Page 1 of 6		Issue Date: June 13, 2022		Case No.: 21-06-3356R		CLOMR-APP	
<div style="display: flex; justify-content: space-around; align-items: center;">  <div style="text-align: center;"> <h2 style="margin: 0;">Federal Emergency Management Agency</h2> <p style="margin: 0;">Washington, D.C. 20472</p> </div> </div>							
<h3>CONDITIONAL LETTER OF MAP REVISION COMMENT DOCUMENT</h3>							
COMMUNITY INFORMATION				PROPOSED PROJECT DESCRIPTION		BASIS OF CONDITIONAL REQUEST	
COMMUNITY	City of Rio Rancho Sandoval County New Mexico			DETENTION BASIN CULVERT FILL		1D HYDRAULIC ANALYSIS HYDROLOGIC ANALYSIS UPDATED TOPOGRAPHIC DATA	
	COMMUNITY NO.: 350146						
IDENTIFIER	Los Diamantes			APPROXIMATE LATITUDE AND LONGITUDE: 35.226, -106.728 SOURCE: OTHER DATUM: NAD 83			
AFFECTED MAP PANELS							
TYPE: FIRM* NO.: 35043C2101D DATE: March 18, 2008				* FIRM - Flood Insurance Rate Map			
TYPE: FIRM* NO.: 35043C2102D DATE: March 18, 2008

TYPE: FIRM* NO.: 35043C2104D DATE: March 18, 2008							
TYPE: FIRM* NO.: 35043C2125D DATE: March 18, 2008							
FLOODING SOURCE(S) AND REACH DESCRIPTION							
Rainbow Tributary – From the confluence with Calabacillas Arroyo to approximately 110 feet upstre

PROPOSED CONDITIONS
HYDRAULIC BASE MAP
FOR
RAINBOW TRIBUTARY - NORTH
LOS DIAMANTES FLOOD STUDY
CITY OF RIO RANCHO, NEW MEXICO
MARCH, 2021

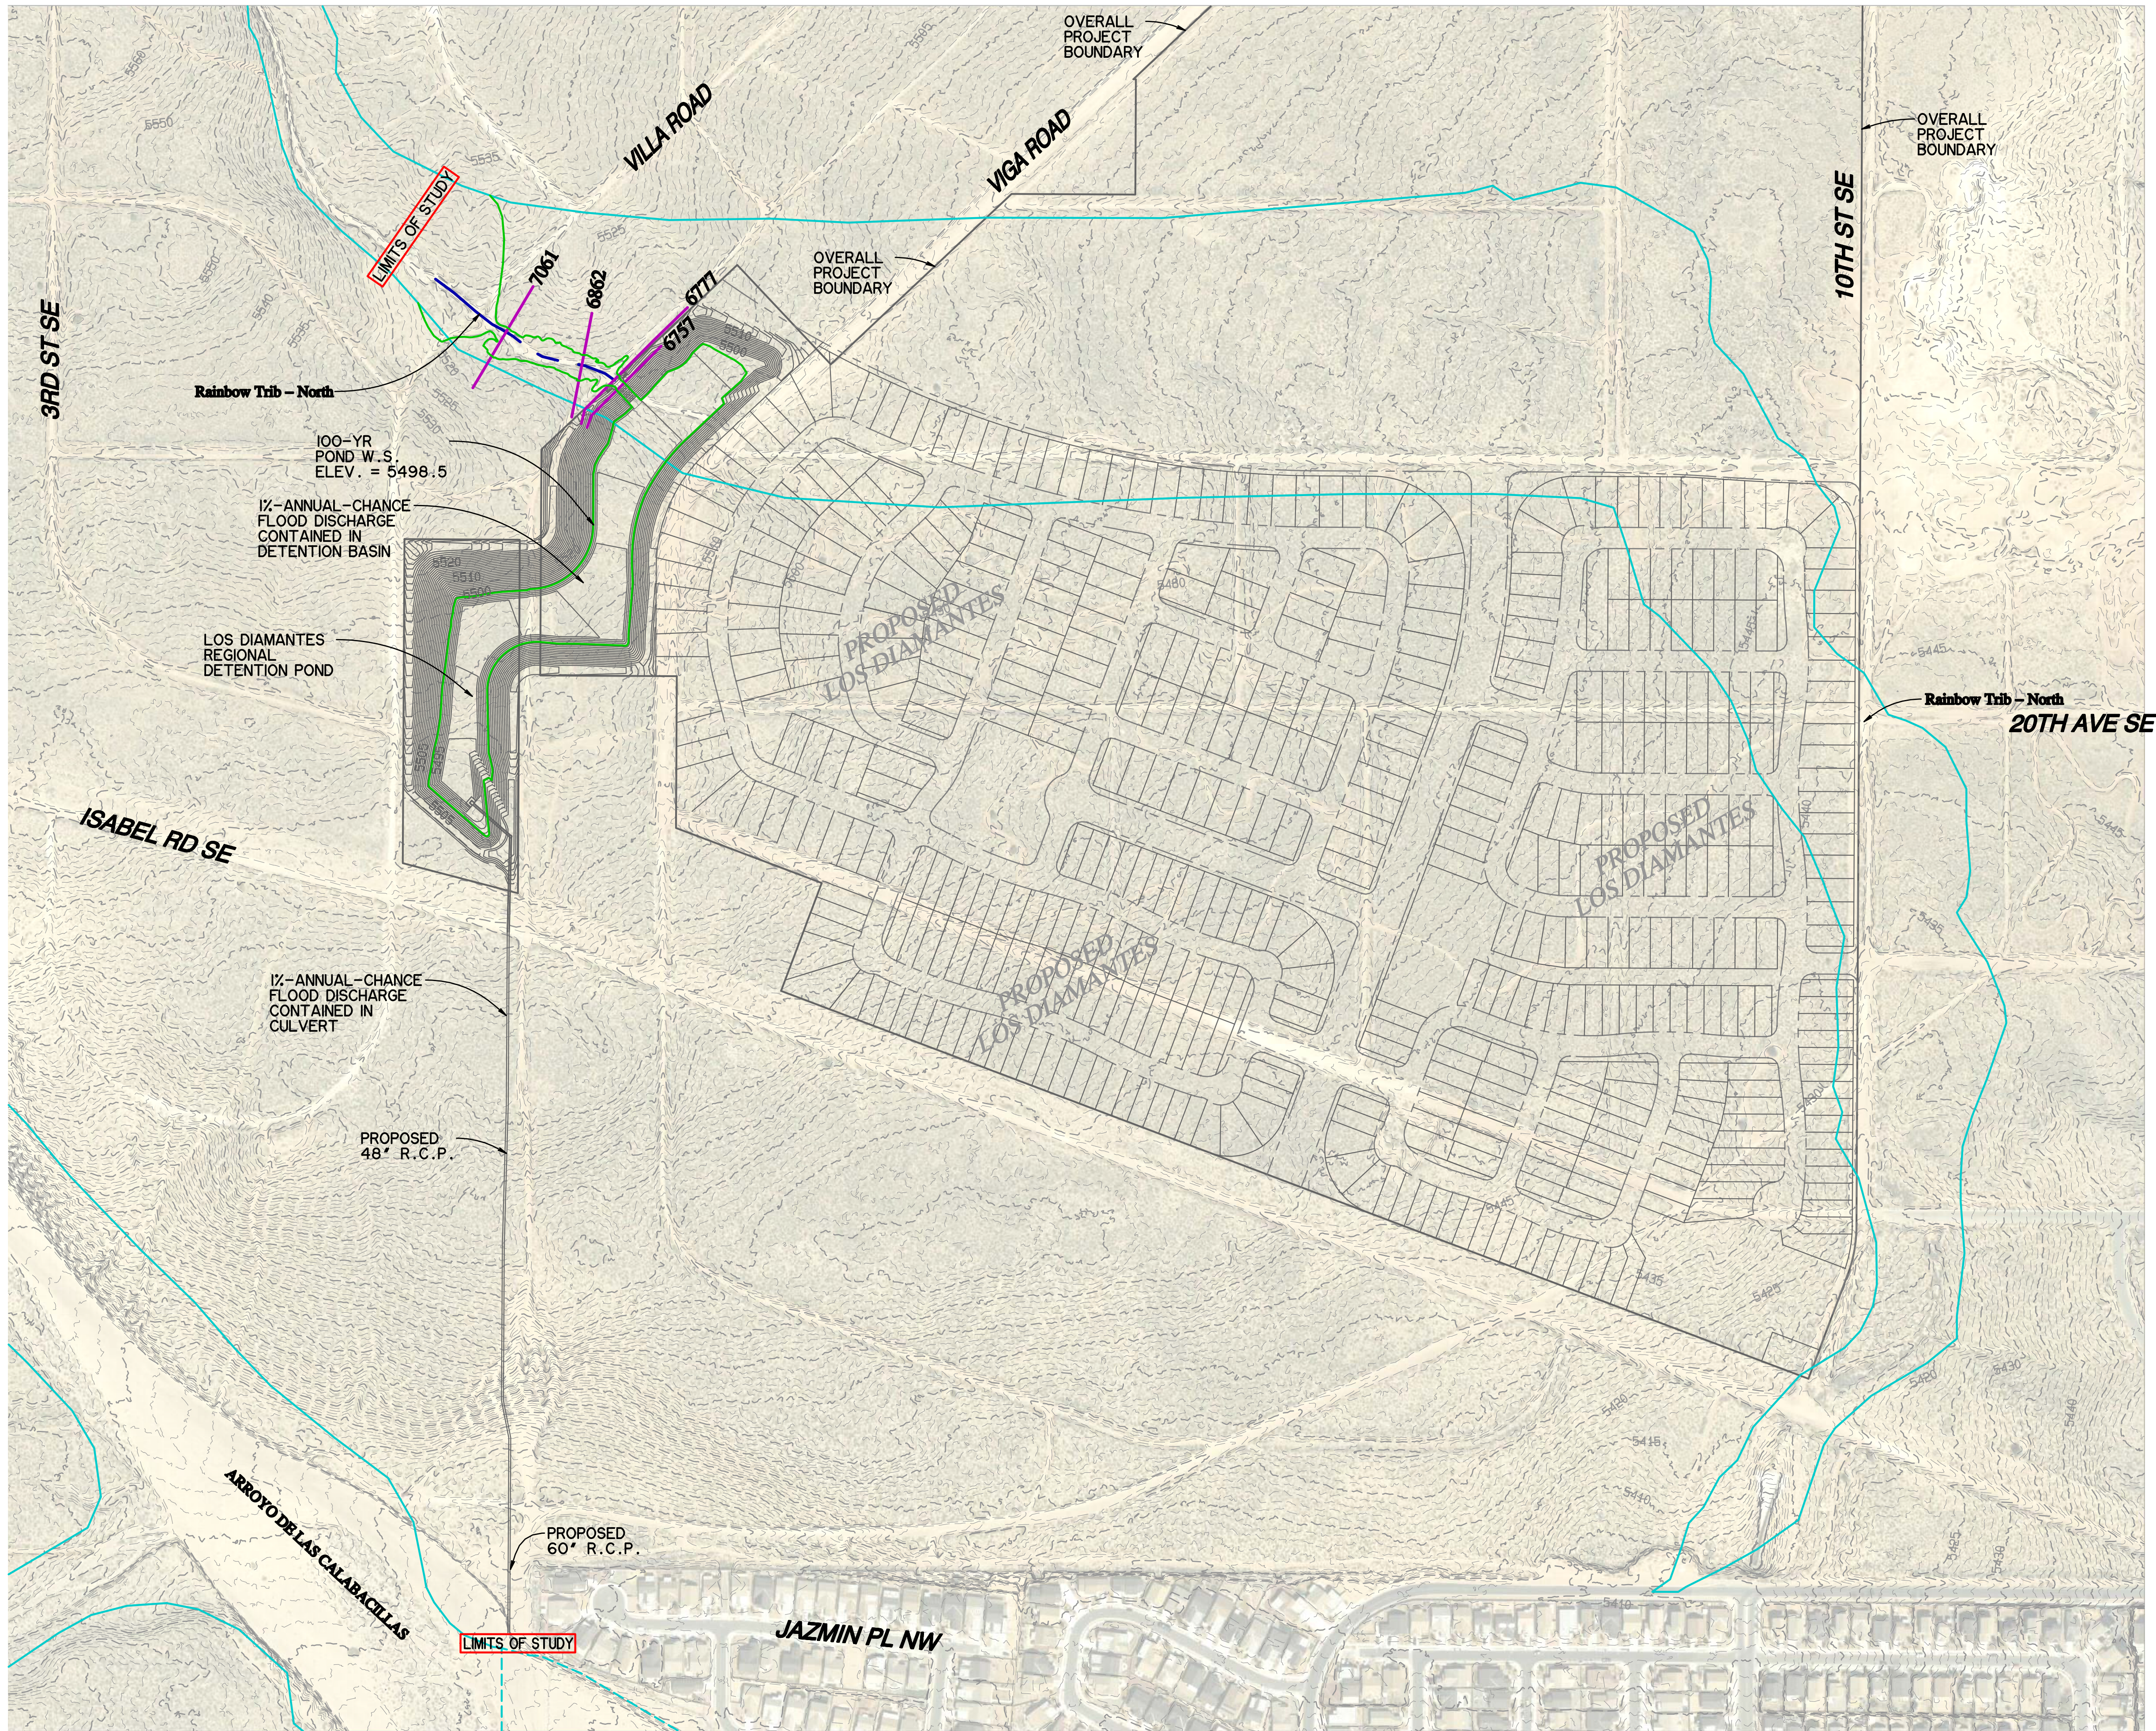
To determine the changes in flood hazards that will be caused by the proposed project, we compared the hydraulic modeling reflecting the proposed project (referred to as the proposed conditions model) to the hydraulic modeling reflecting the existing conditions.

The table below shows the changes in the base flood water-surface elevations (WSELs).

Flooding Source: Rainbow Tributary		Base Flood WSEL Change (feet)	Location of maximum change
Proposed vs.	Maximum increase	0.1	Approximately 370 feet downstream of Villa Road
Existing	Maximum decrease	NONE	N/A
